SITE: Hook Lane, Westergate
Internal Site Road Layout

REPORT: Stage 1
Preliminary Design – Road Safety Audit
Designer's Response

REPORT DATE: 25th May 2016

REPORT REF: KJ/BSO/E4462/16116

Drawing No. BSO/E4462/002 E

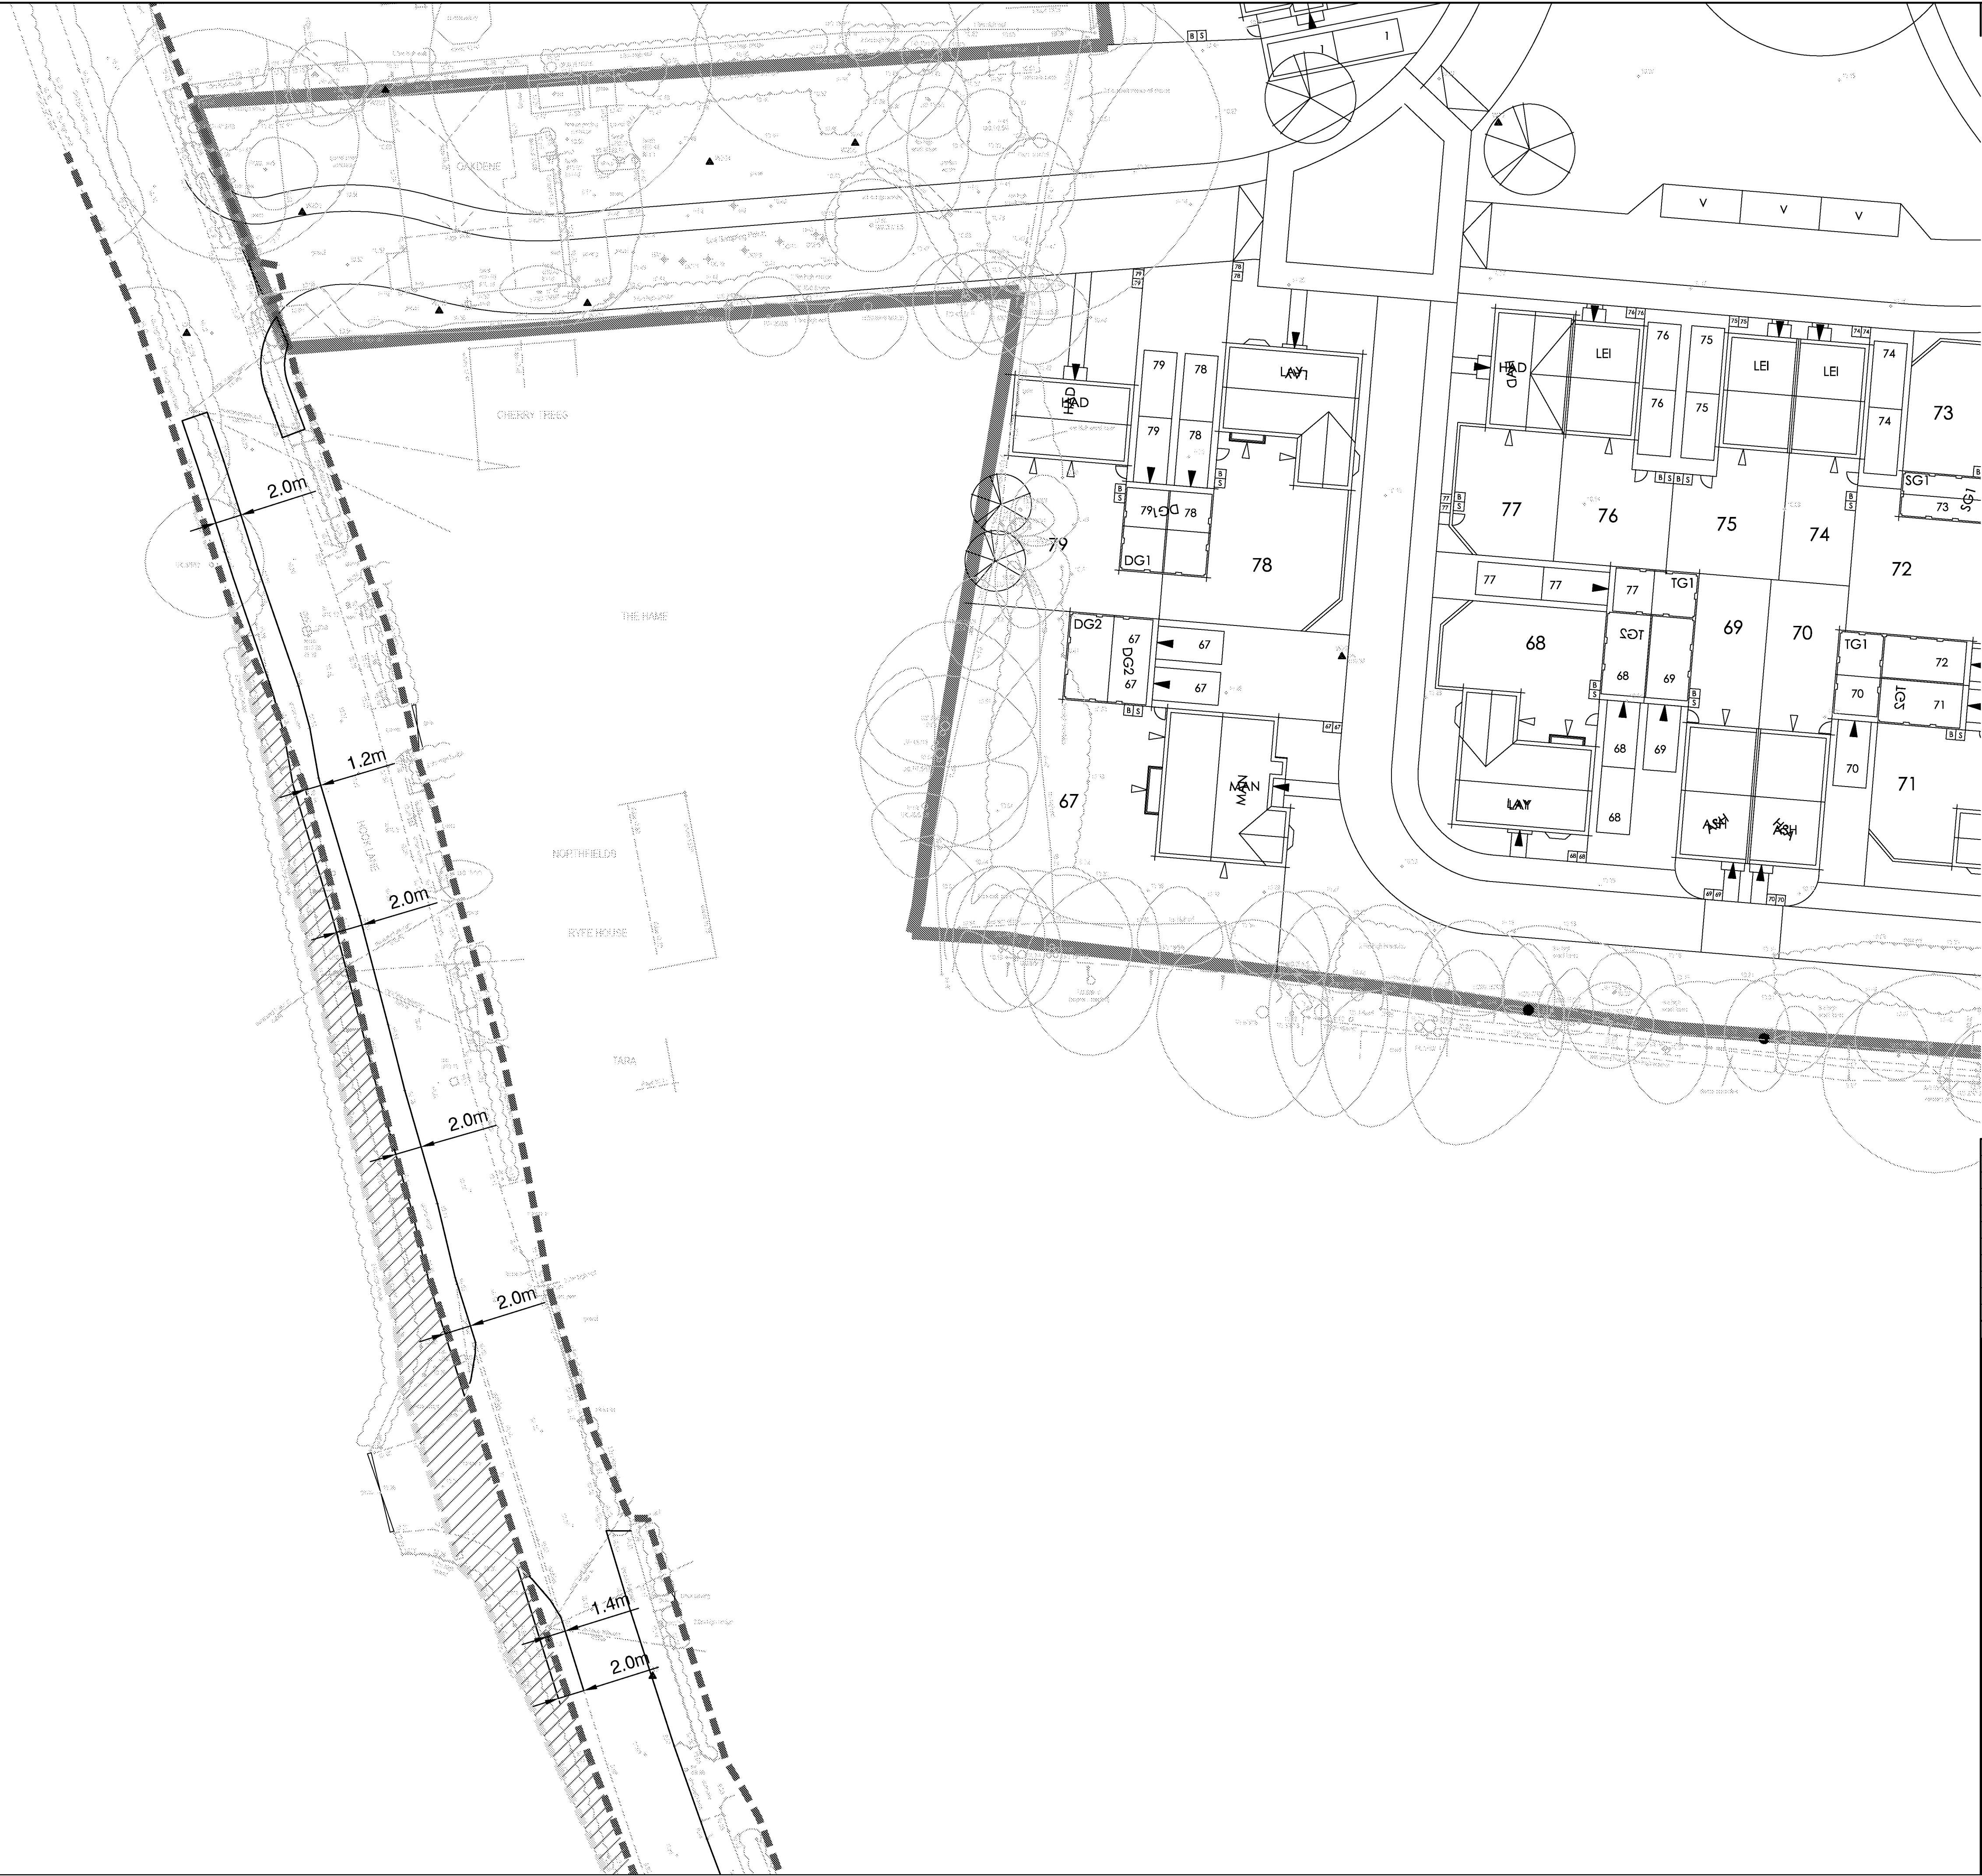
- 3.2.2 Tracking provided is to indicate a fire tender can access points on the site. Shared access routes are designed in accordance with Manual for Streets with regard to fire tender access.
